Reference No: 2020/NM/92830/W

Site Address: 43, Birkby Lodge Road, Birkby, Huddersfield, HD2
2BE

Description: Non material amendment to previous permission
2020/90414 for erection of detached garage

DECISION – Non-Material Amendment Approved

43 BIRKBY LODGE ROAD BIRKBY
DRG NO 1936-5D SCALE 1-50

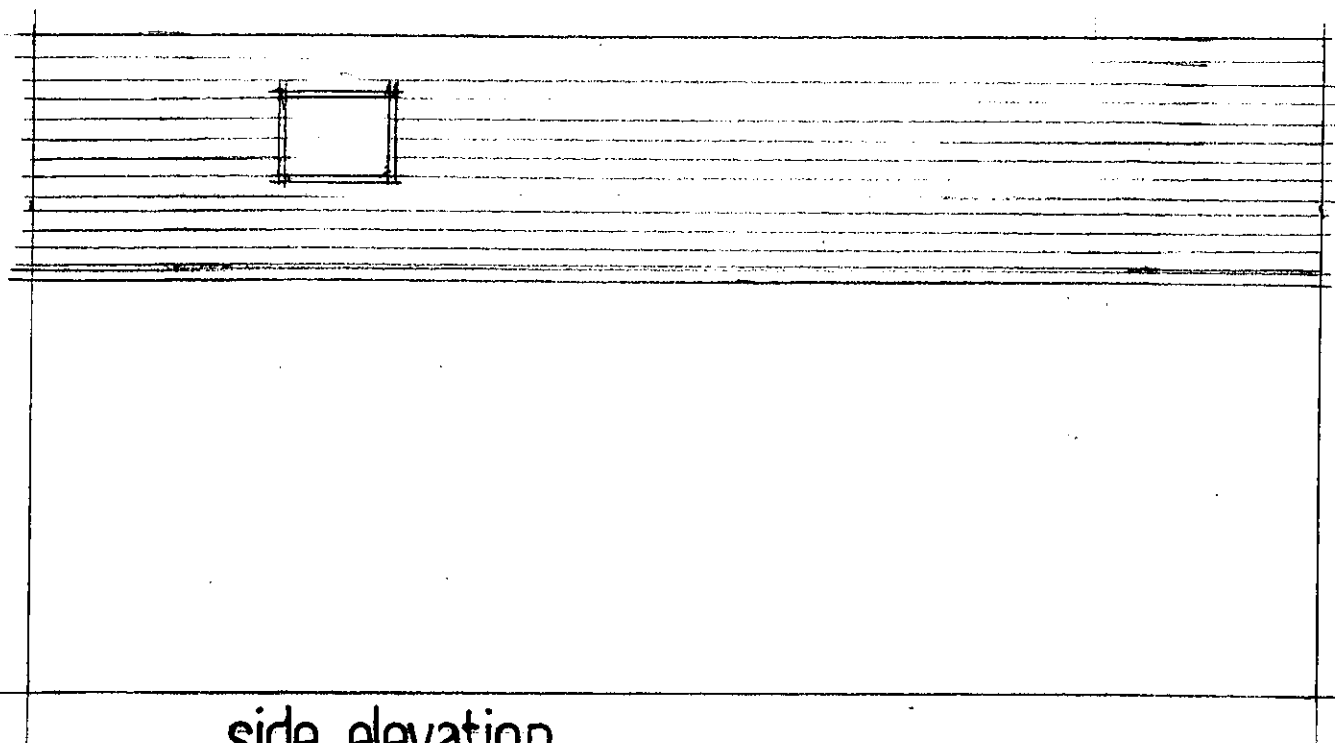
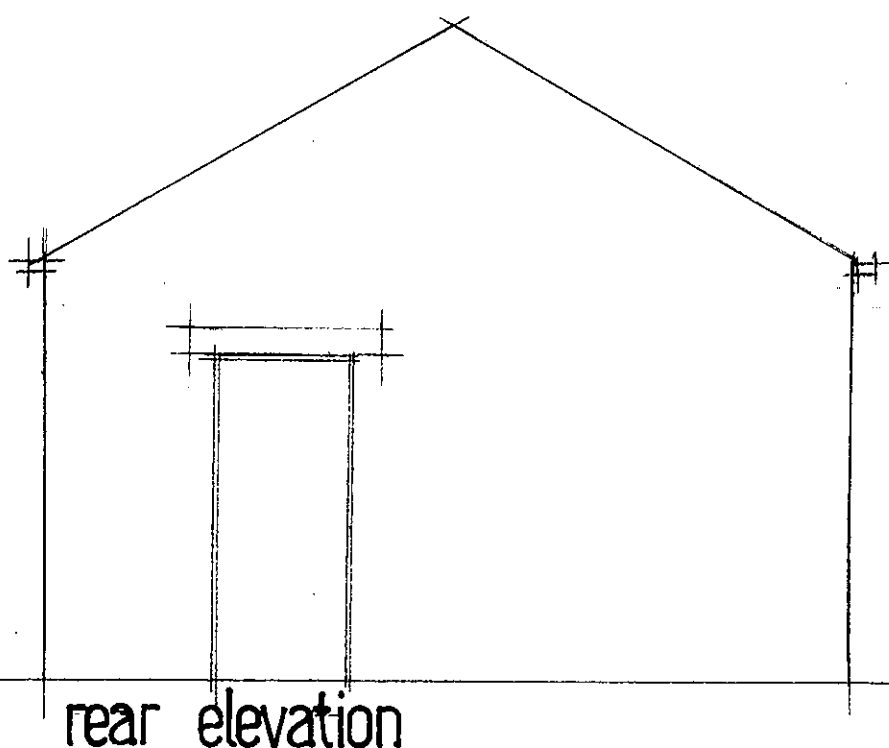
The amendment seeks to include two roof lights within the dual pitch roof as shown on plans 1936.4 D and 1936.5 Rev D.

Officers do not consider the proposed roof lights to visually change the scheme, when considering what was previously approved. More specifically, the new additions would appear relatively small in size and scale, when read against the overall roof form.

With regards to residential amenity, it has been noted that the works proposed would not unduly prejudice neighbouring properties, as the applicant is only seeking permission for these openings, in order to allow natural light into the garage. The roof lights would not provide an outlook into neighbouring gardens and therefore the council are satisfied that no privacy will be lost.
